**From:** [Peter Bleasdale](#) on behalf of [Airspace Protection](#)  
**To:** [Andrew Watson](#)  
**Cc:** [David Glasgow](#)  
**Subject:** RE: Request for advice - Response to Submissions - Eden Street, Arncliffe - Mixed Use Redevelopment (SSD-11429726)  
**Date:** Wednesday, 16 February 2022 12:25:28 PM  
**Attachments:** [image001.png](#)  
[image005.wmz](#)  
[image006.png](#)

The Architectural drawings provided show a proposed development with a maximum height of 98.25m AHD

The Obstacle Limitation Surface over the site is 51m AHD.

Figure 2 70m height plane diagram

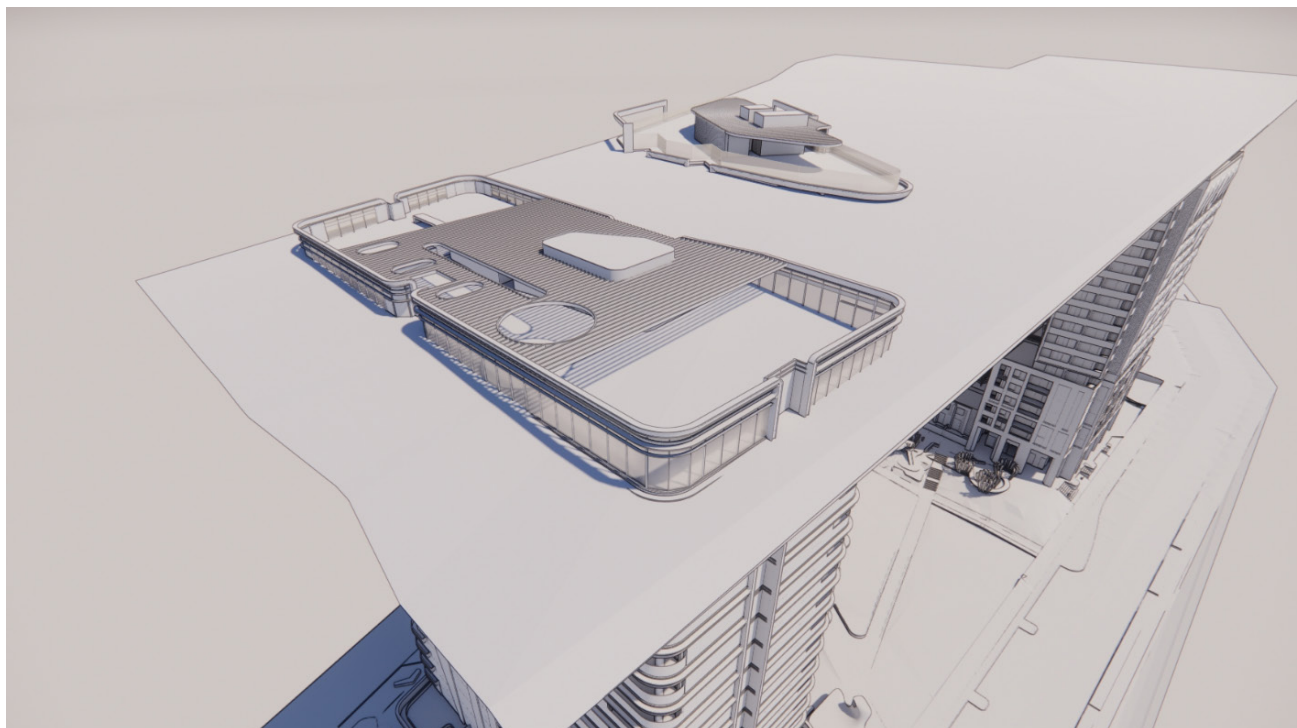
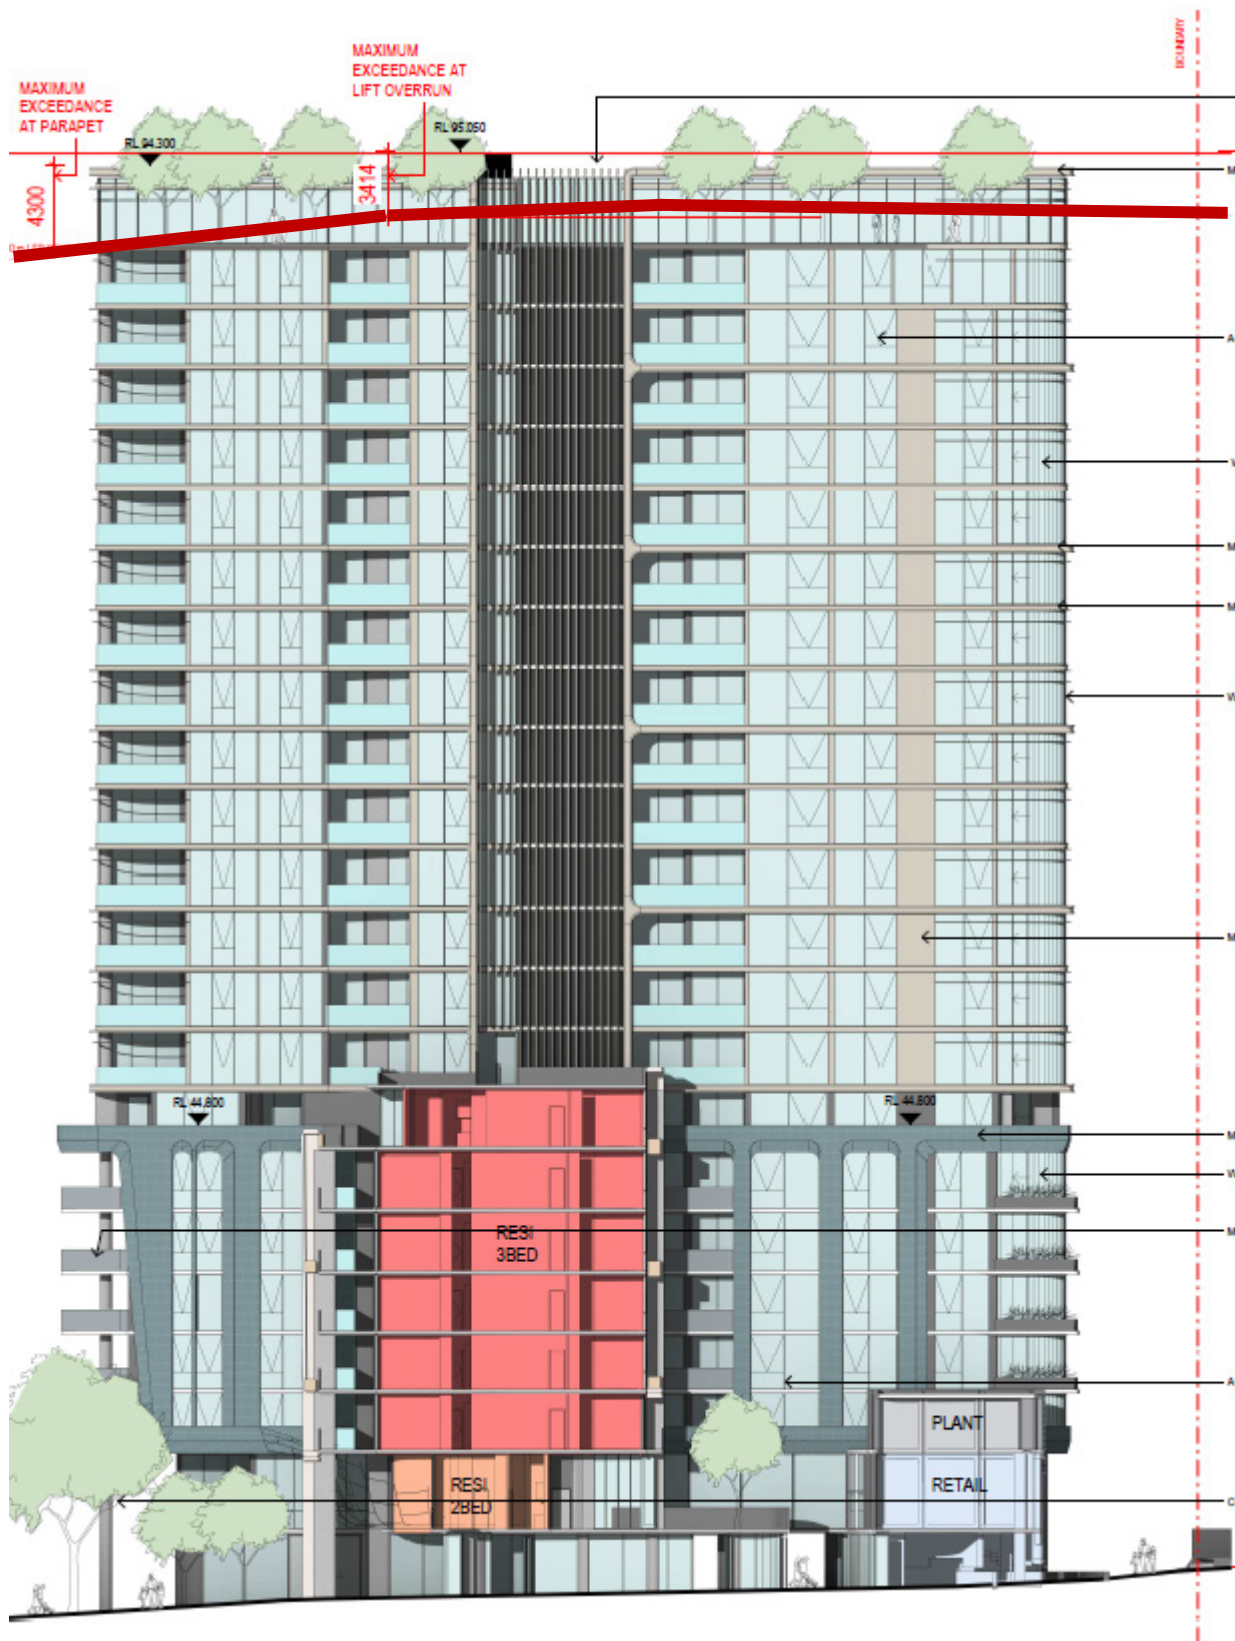
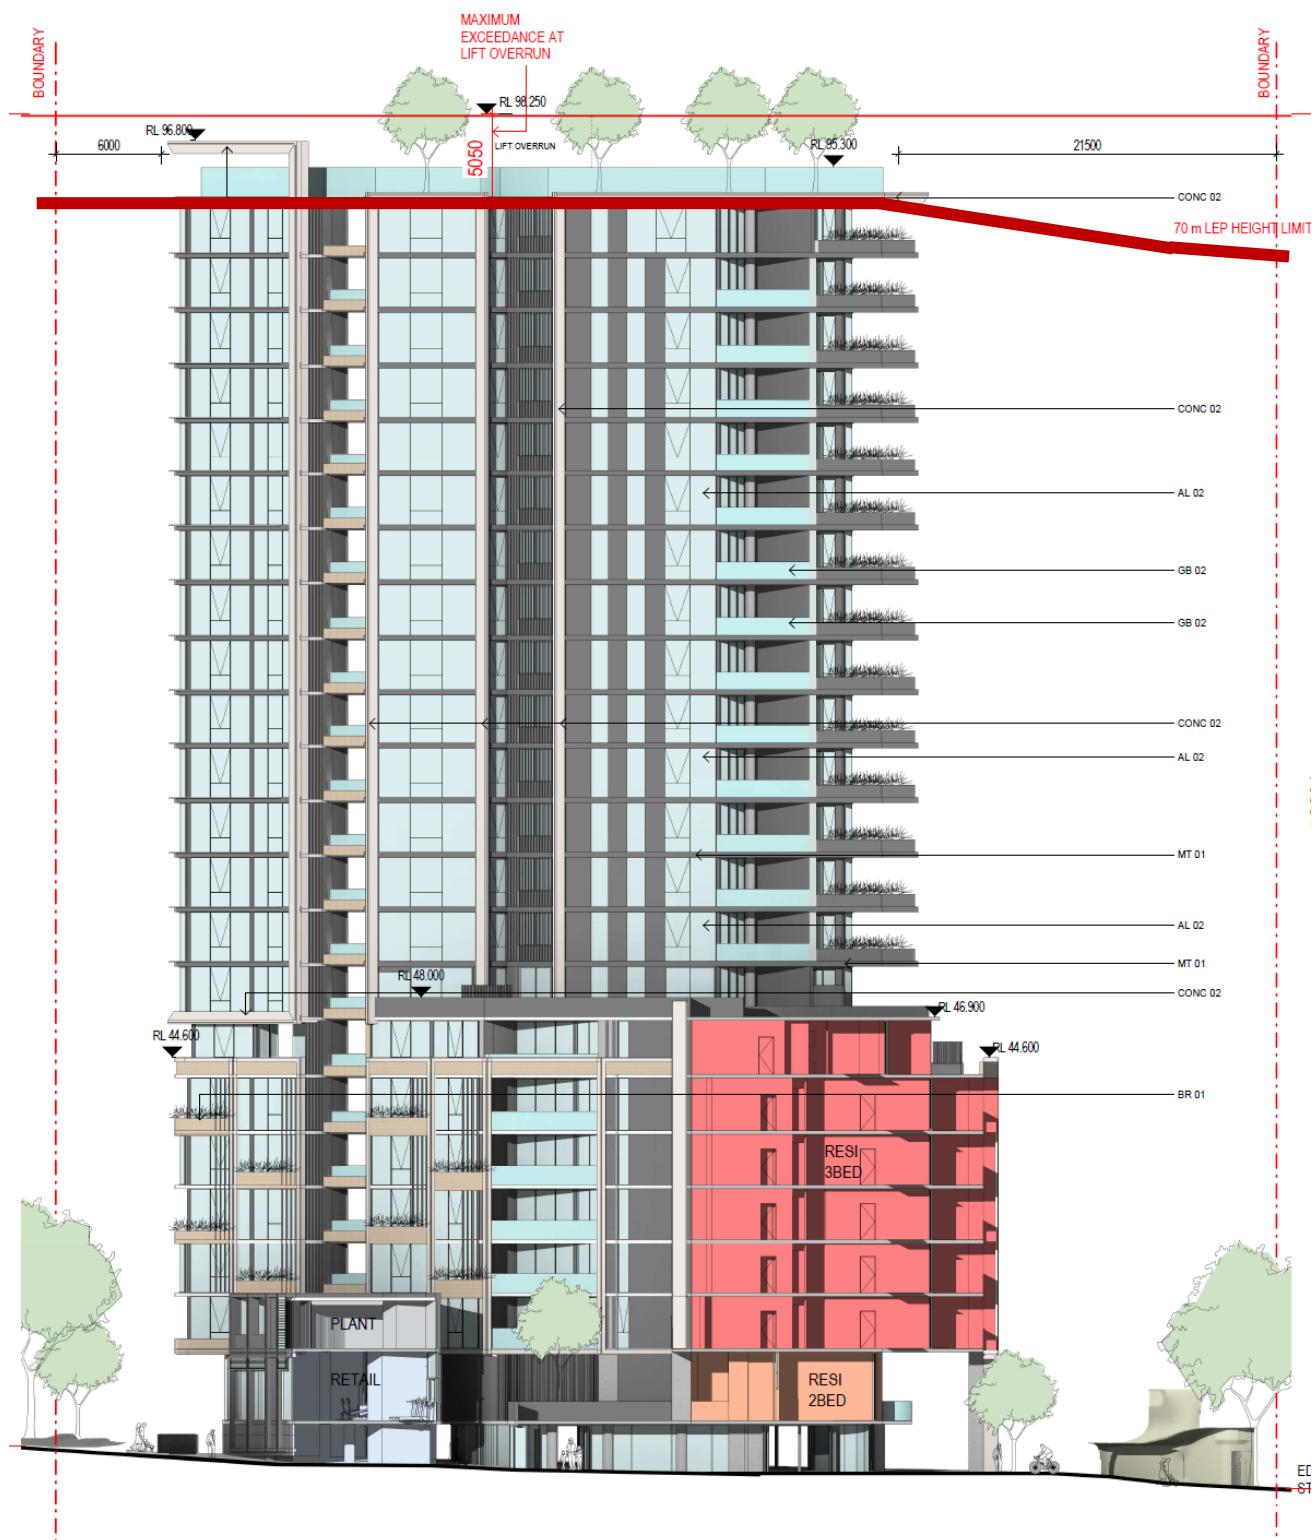
Any such proposed development would be subject to assessment & approval By the Federal Department of

Infrastructure, Transport, Regional Development and Communications under the - Airports (Protection of Airspace)

Regulations 1996
